# CITY OF ALBUQUERQUE

**Re: La Orilla Storage  
Erosion and Sediment Control Plan  
Engineer's Stamp Date 10-17-17 (E12E006E)**

TITLE: GUARDIAN STORAGE EROSION & SEDIMENT CONTROL PLAN

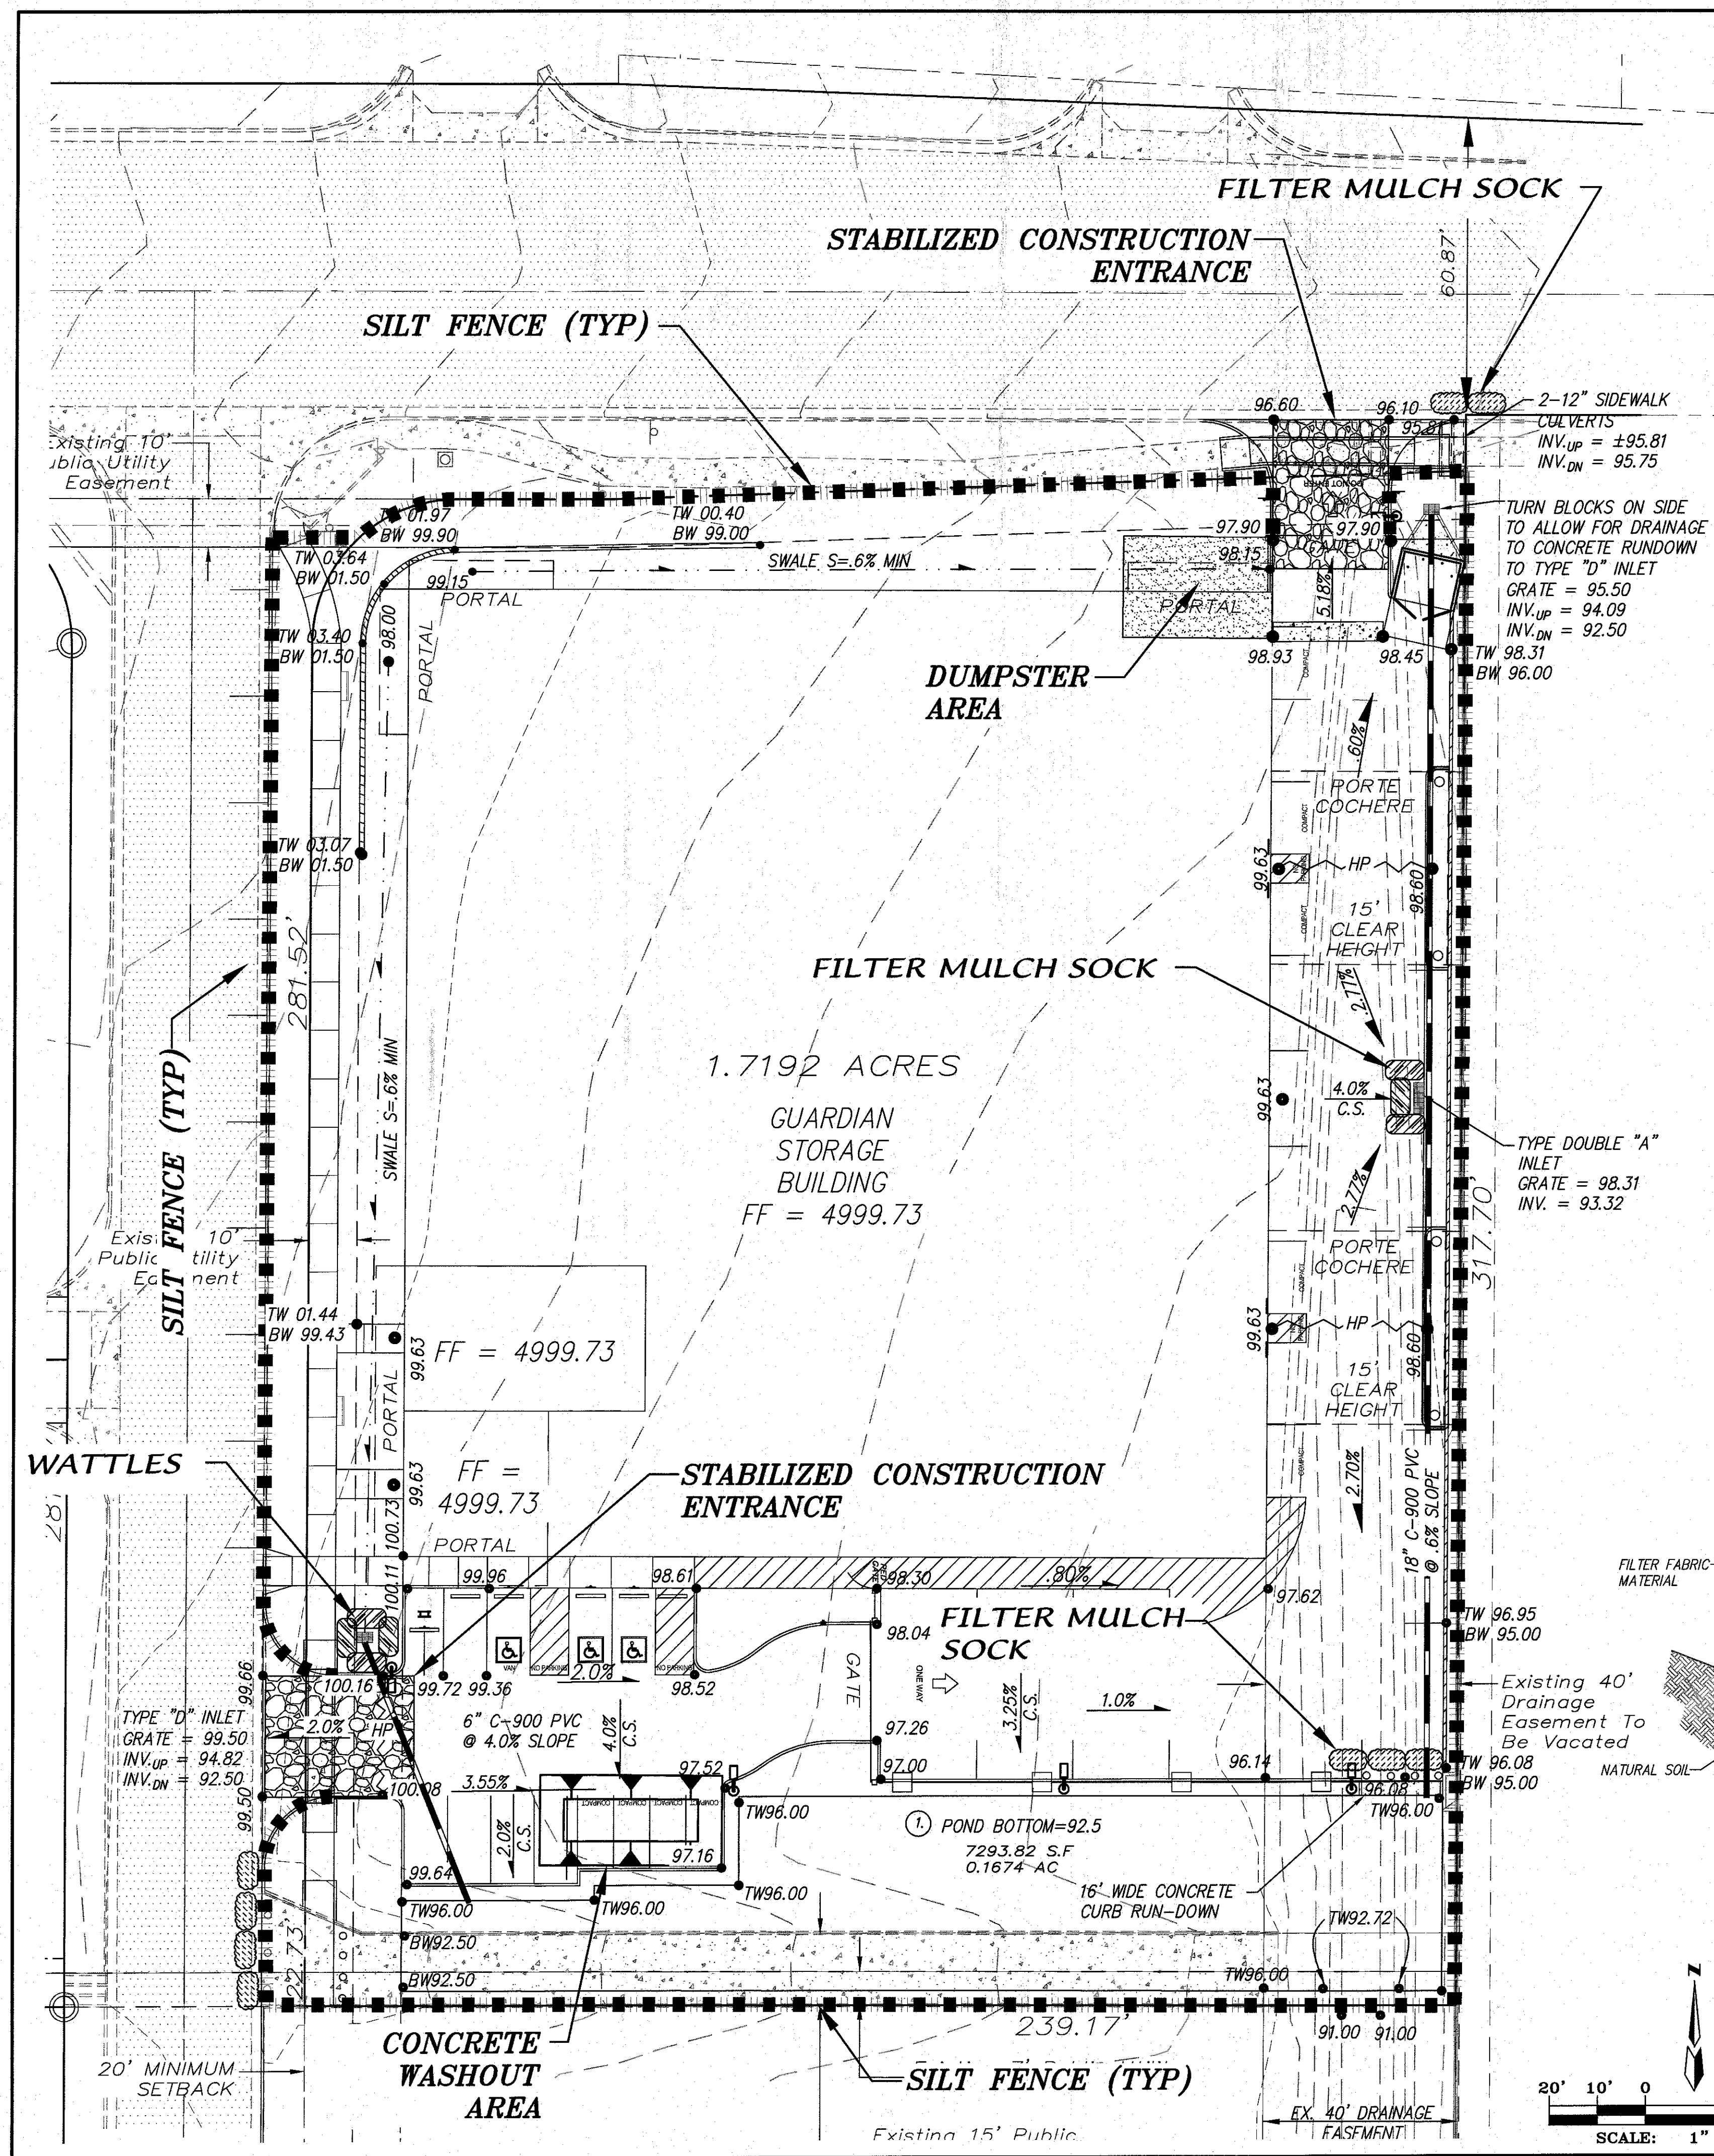
1. Show erosion and sediment controls on the grading plan that is submitted to Hydrology. Some line types/text on the grading plan may have to be lightened for clarity.
2. It appears there is a pond in the southeast area of the site. The pond or at least a significant portion of it is to be graded with initial grading. The pond can be shown (build note) as a sedimentation pond.
3. This site will receive offsite flows from La Orilla Rd. They can be routed to the pond in the southeast area or ponded closer to La Orilla Rd. Add a note on how you propose to address offsite flows.
4. Is the gap in silt fence in the northeast corner for the above mentioned offsite flows?
5. Project limits are not clear. Aerial imagery shows a concrete channel terminating 40 feet west of the east property line, whereas this plan shows the concrete channel terminating at the east property line.
